From: Julia Davies [REDACTED]
Sent: 21 May 2020 07:50
To: Zac Denton <Zac.Denton@arun.gov.uk>
Subject: Re: 54 Torton Hill Road (AB/23/20/HH)

Drawing P03a March 2020 Scale 1:500 & 1:1250 @ A3
Planning Drawing - Block Plan & Location Plan

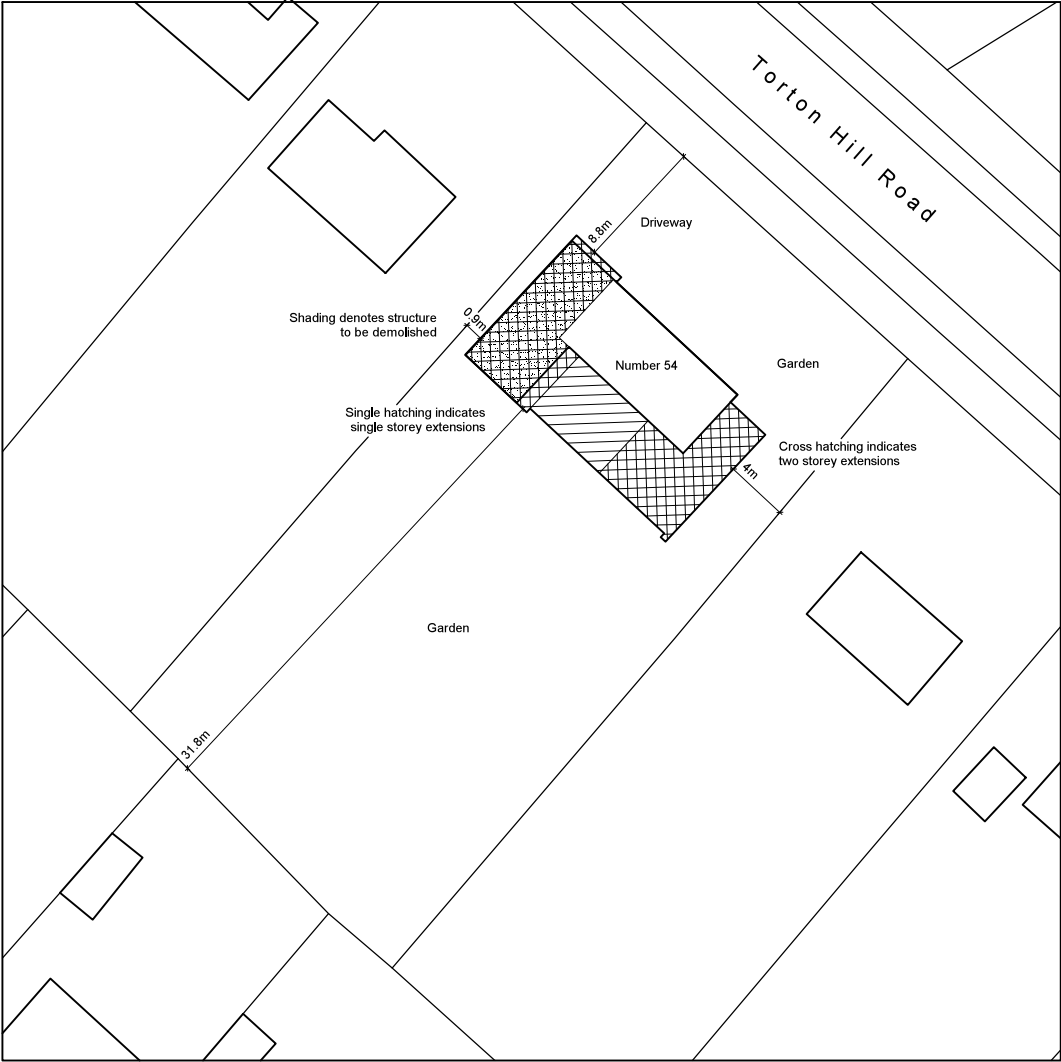
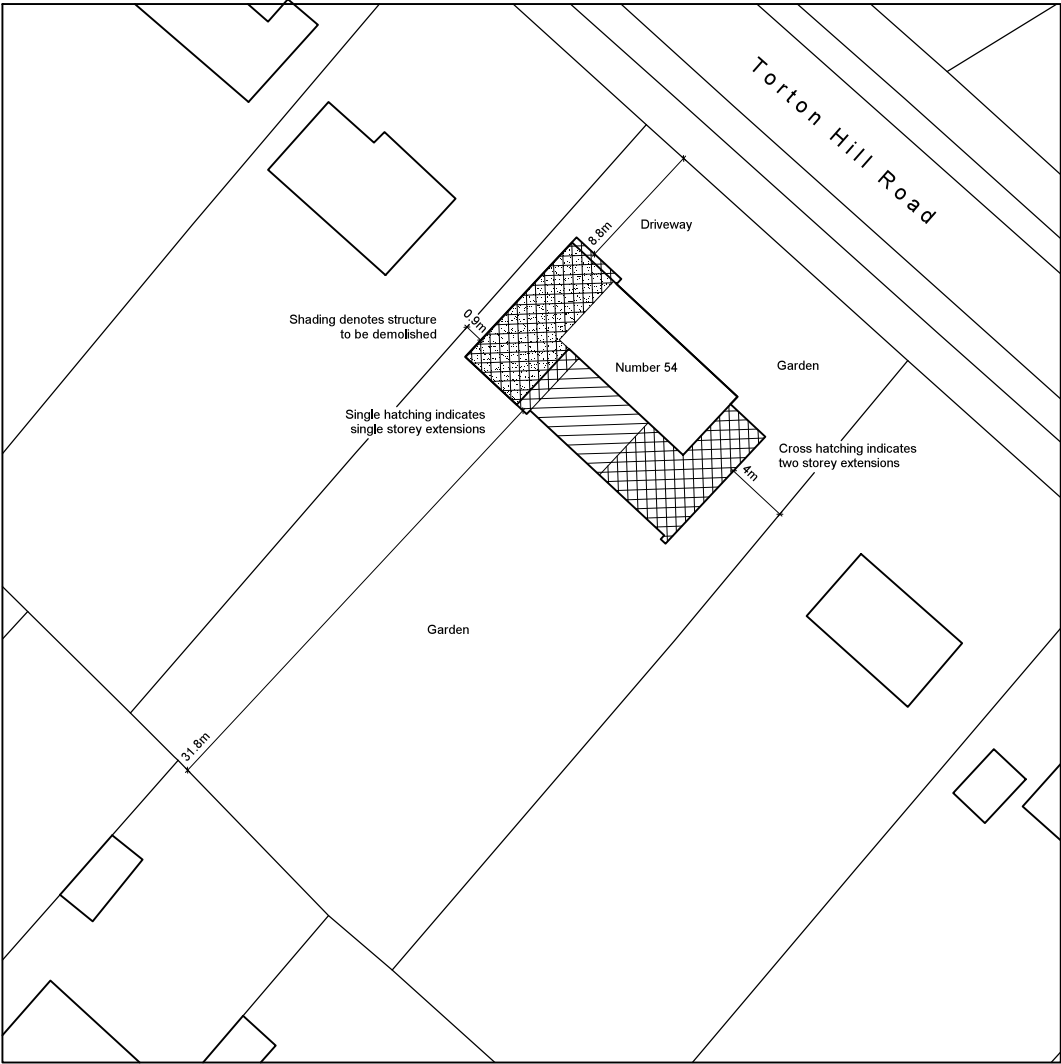
As the red line around the site now includes the pavement within the ownership of the LHA, do I need to serve notice on them and re-issue the application form with Certificate B completed? Or as the LHA have been / will be consulted as part of the application, is this necessary?

You will also need to provide an application form showing that you have served notice on the LHA as the landowner of the area of land.

Drawing P04a March 2020 Scale 1:250 @ A3
Planning Drawing - Existing & Proposed Site Plan

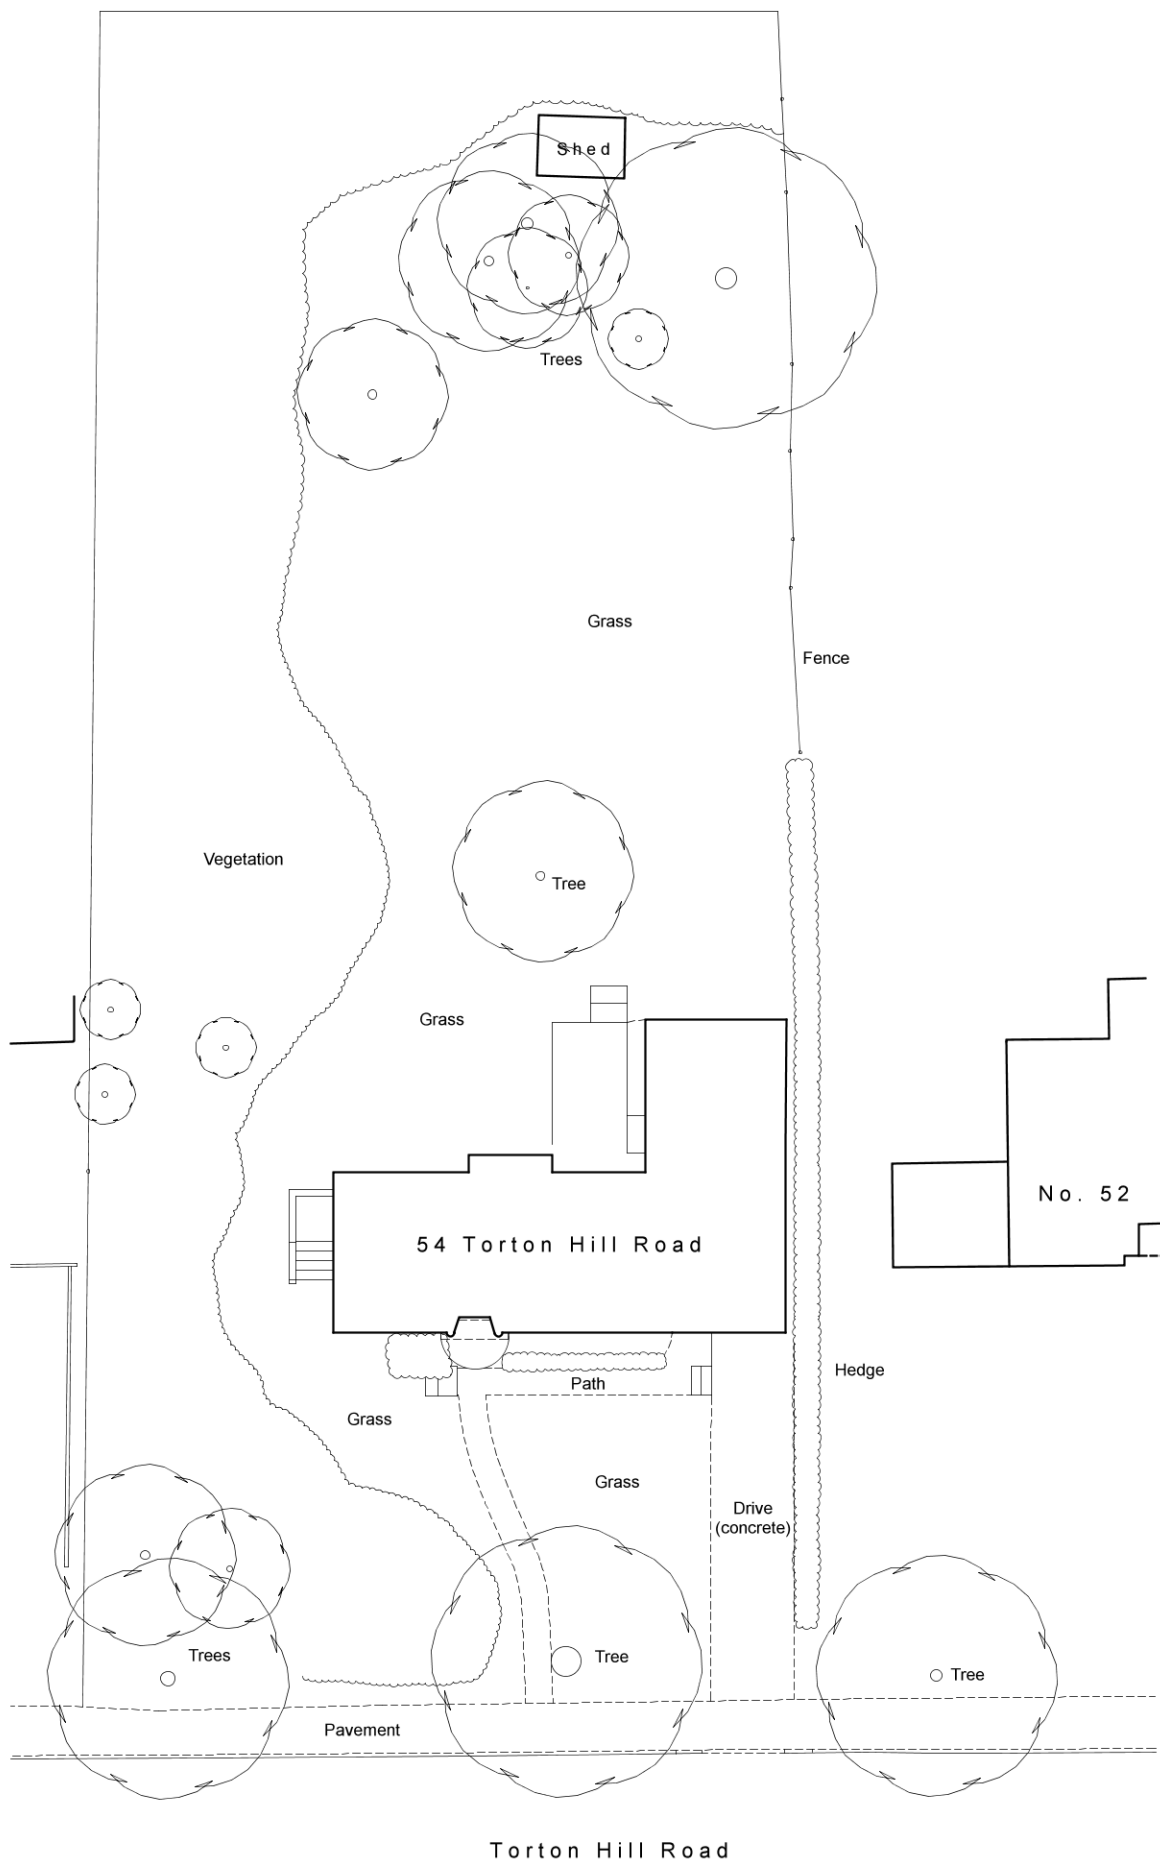
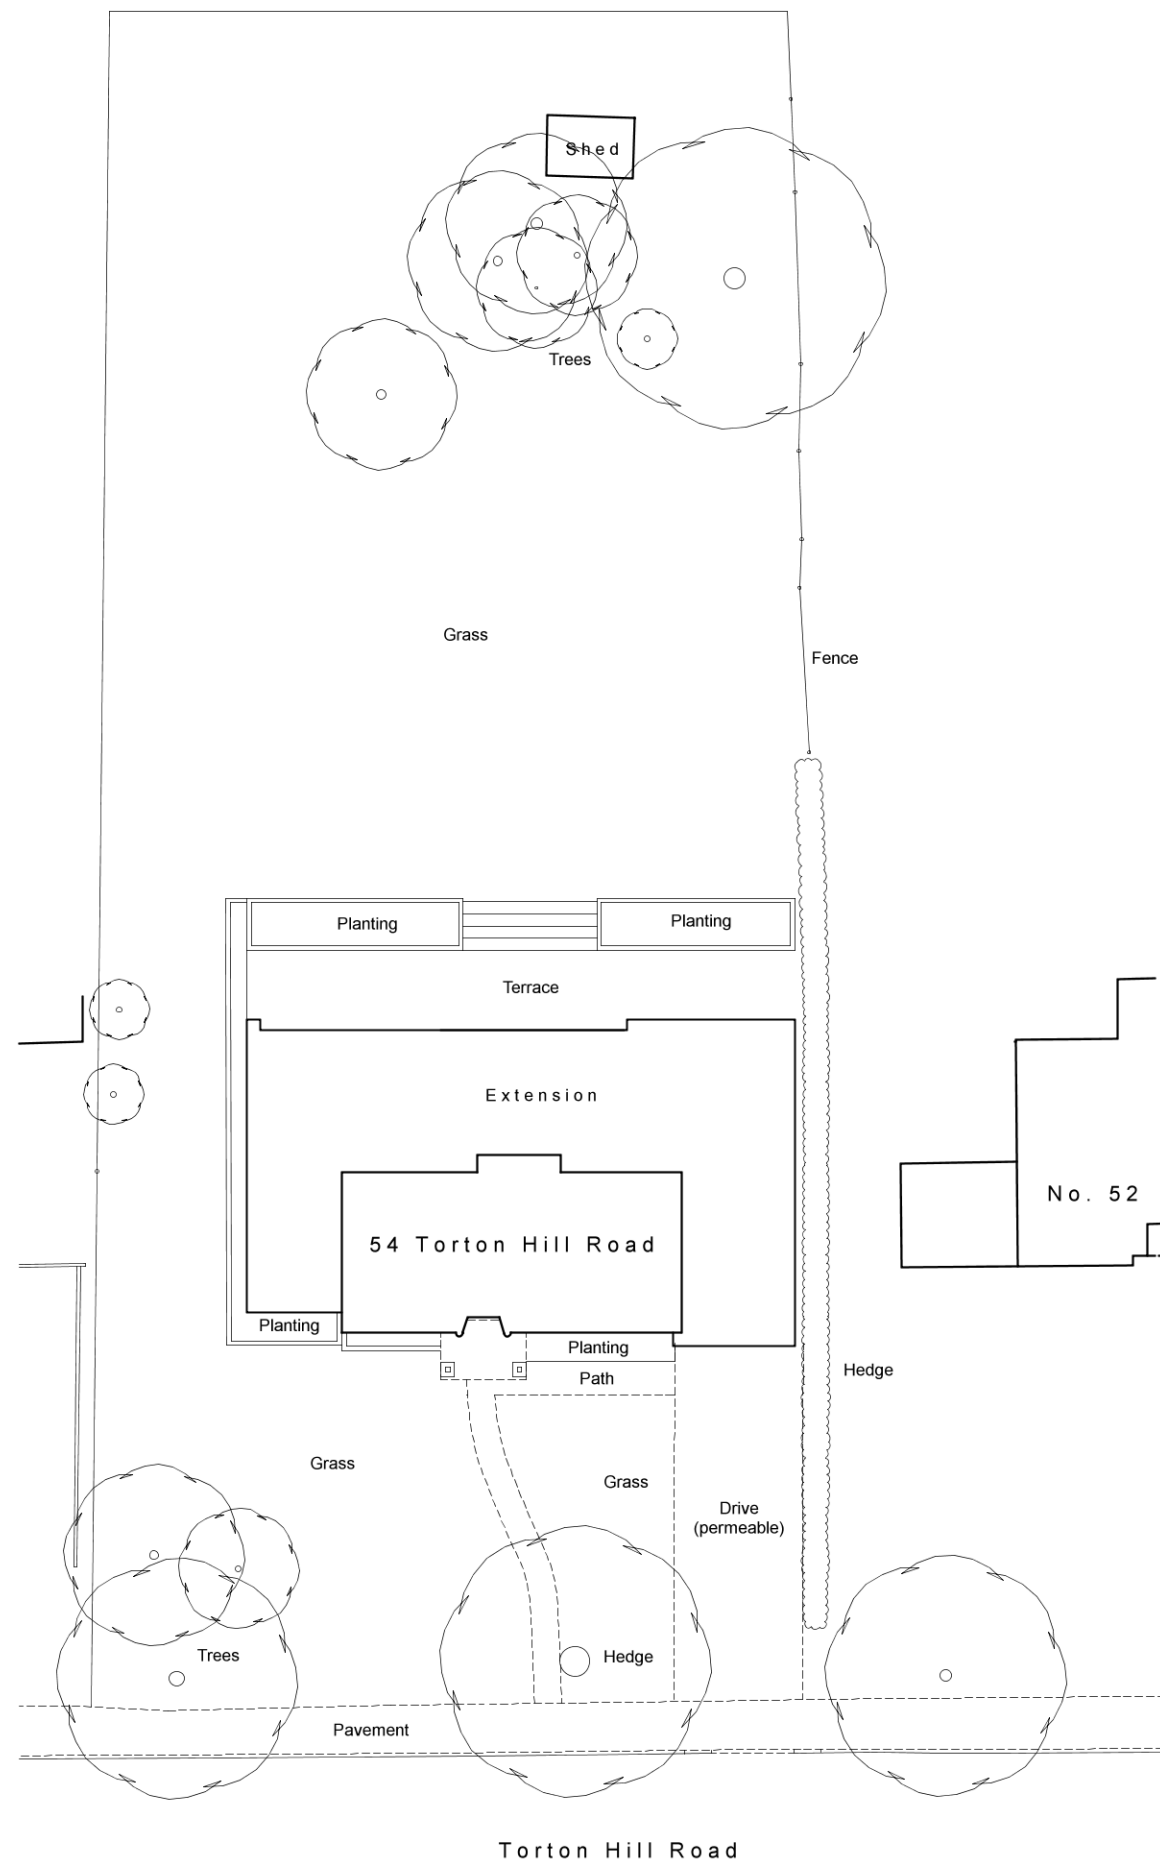
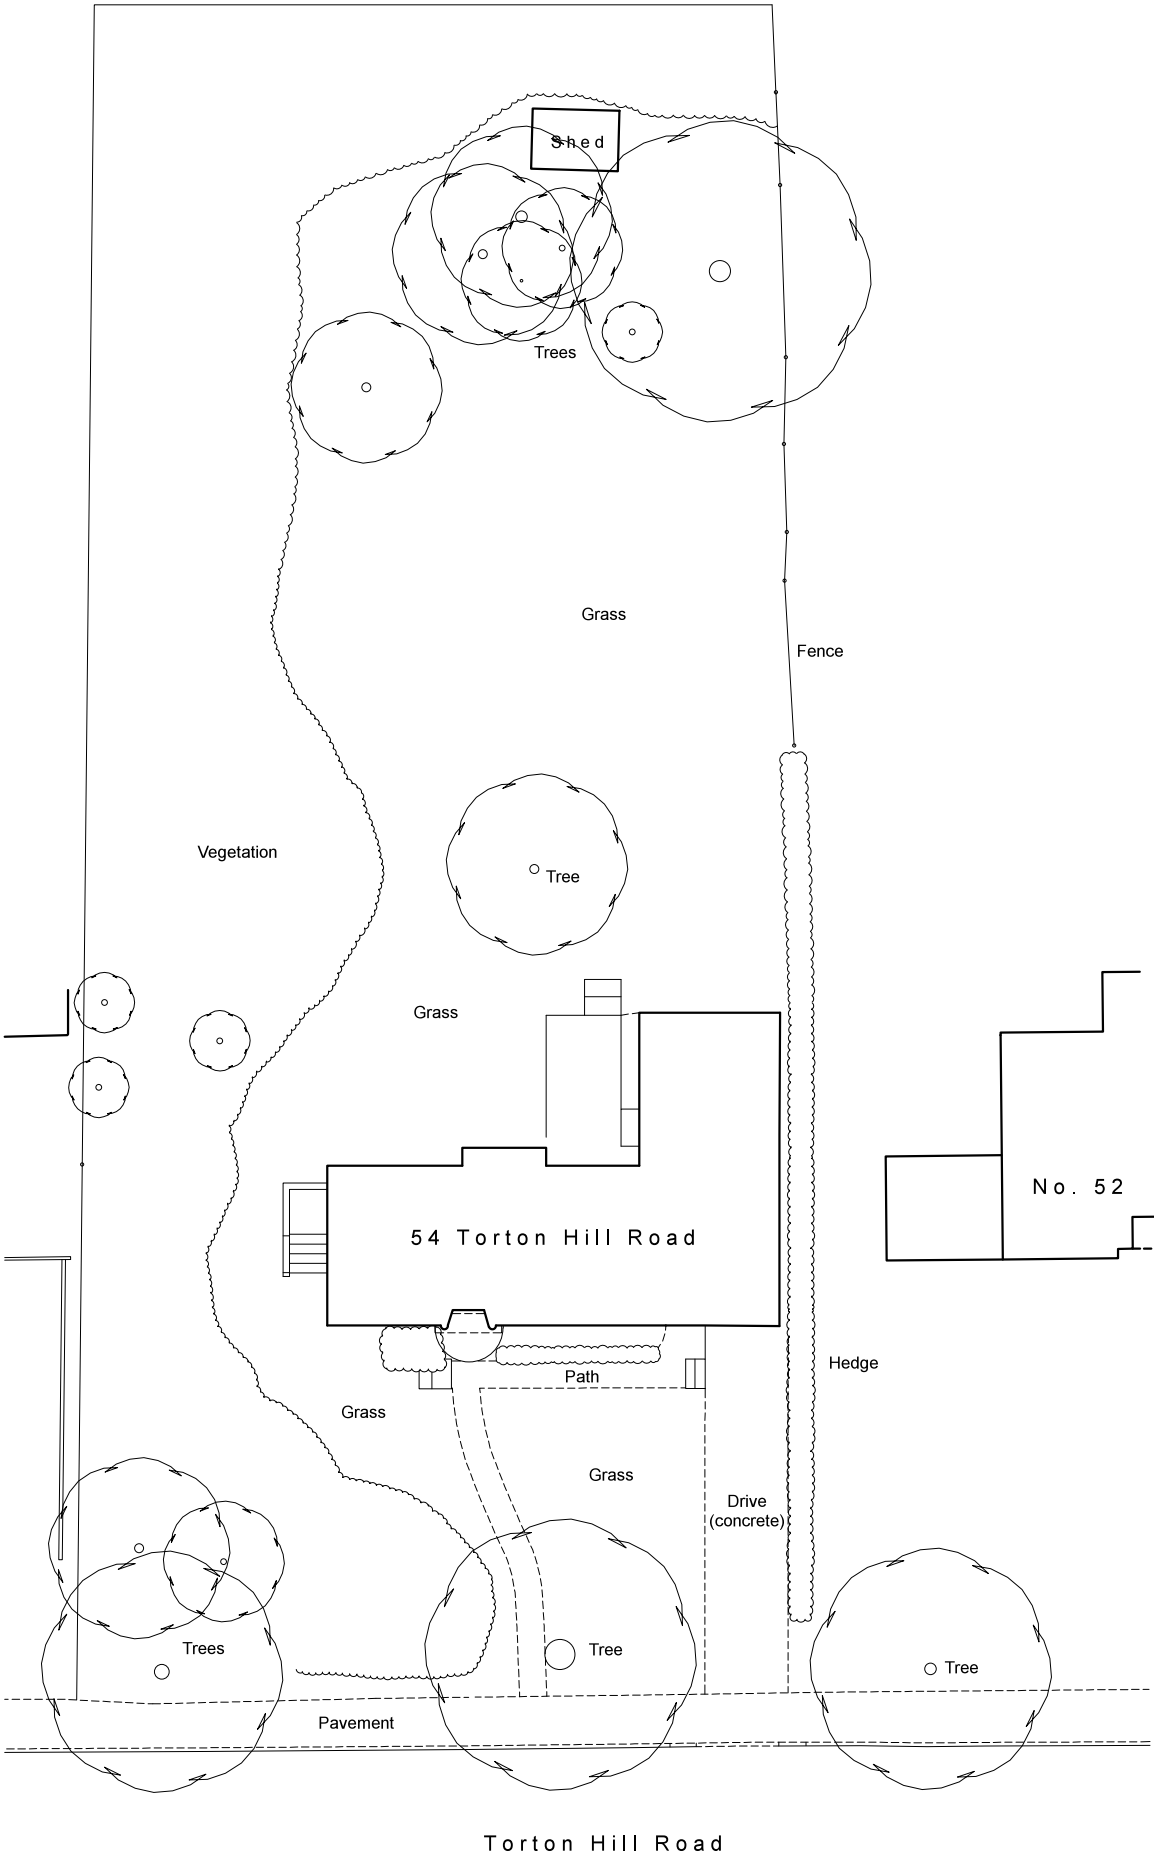
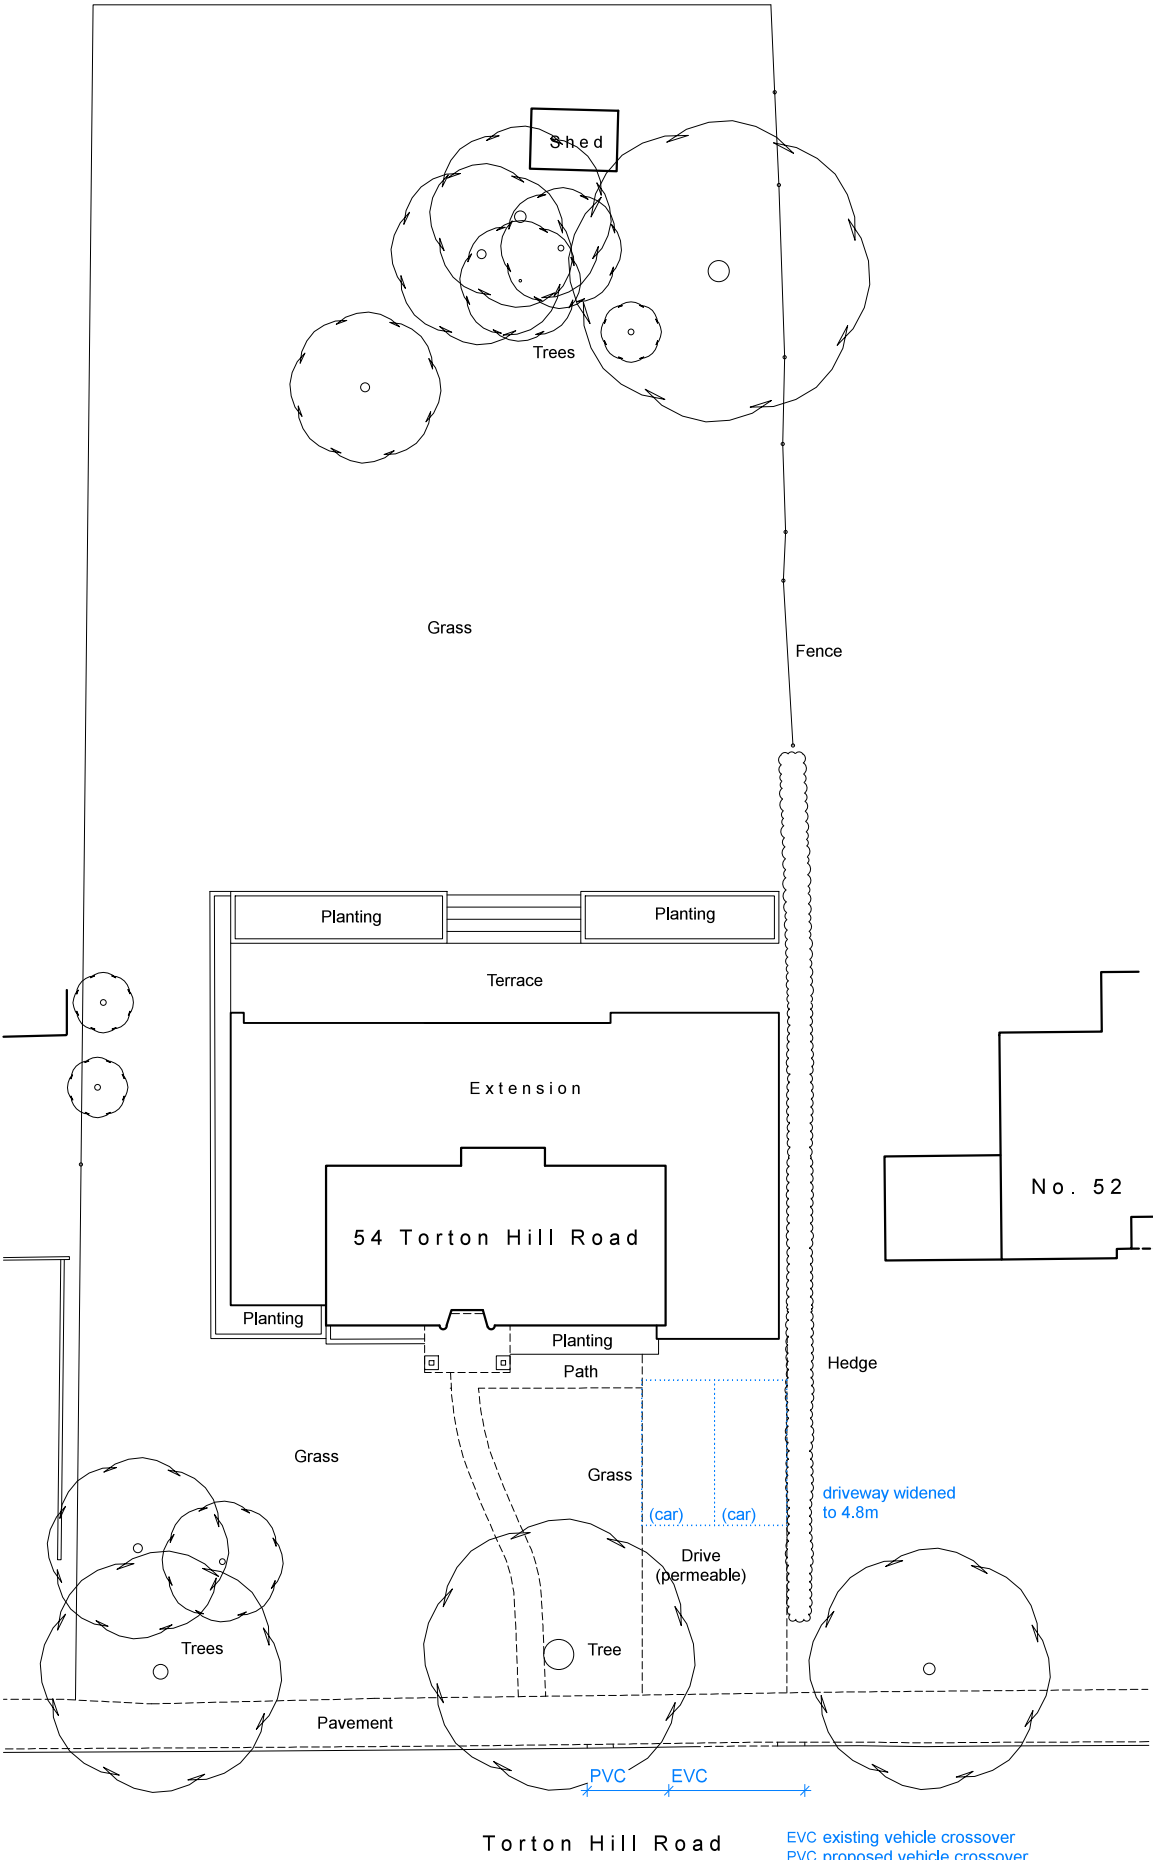
The issues raised by the LHA relating to the VCO width, and that of the hardstanding are materials considerations. If you wish to make the alterations and submit substitute plans, I am happy to accept them.

I have noticed that WSCC Highways have commented on the above application, and requested that the driveway is widened by 0.5m.

Further to my email yesterday, please find attached copies of revised drawings P03a and P04a, which are to supersede drawings P03 and P04 respectively.
